**KIRKLEES METROPOLITAN COUNCIL
INVESTMENT & REGENERATION SERVICE**

**DELEGATED DECISION FOR APPLICATION FOR CERTIFICATE OF
LAWFUL DEVELOPMENT**

Reference no.: 2024/CL/92468/E

Site: 60, Walker Street, Thornhill Lees, Dewsbury,
WF12 0AS

rear elevation

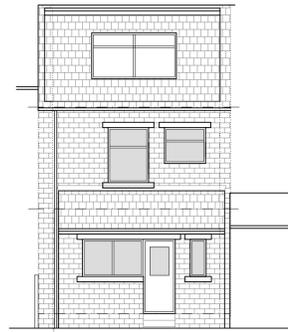
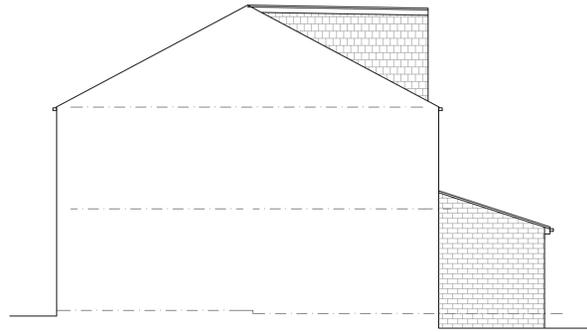
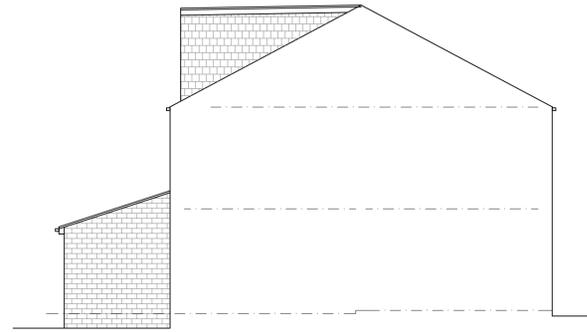
The extension as proposed does not project 3m past the rear elevation or exceed 4m in height.

The eaves are proposed to be less than 3m.

The proposal does not exceed the height of the existing roof.

The proposals would not extend beyond the existing roof slope of the principal elevation, the extension will be on the rear roof plane.

Ground floor plan

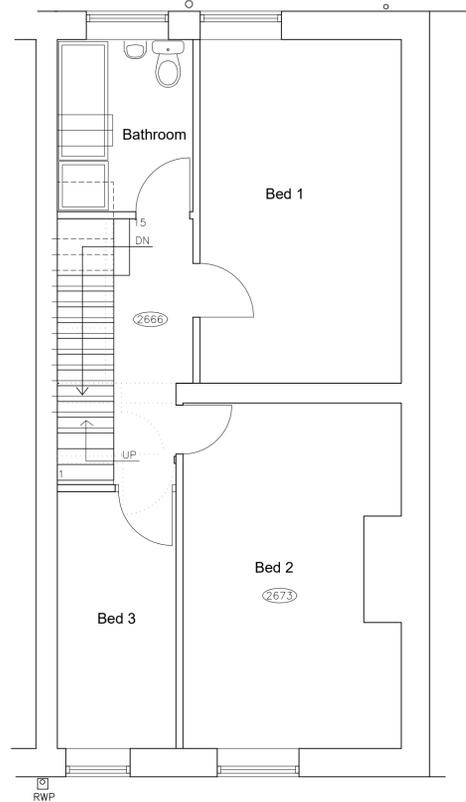
As can be seen from the proposed ground floor plan provided by the applicant, the proposed extensions would not take up more than 50% of the area of the curtilage of the dwellinghouse.

Second floor plan

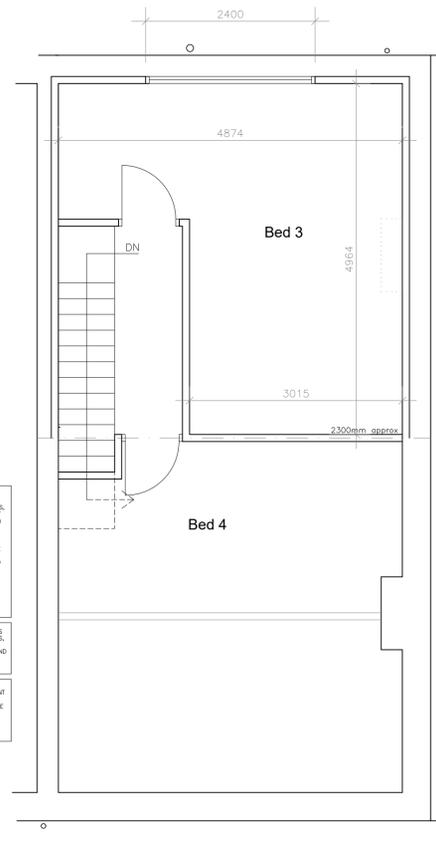
Total additional roof space 32.50 cubic meters
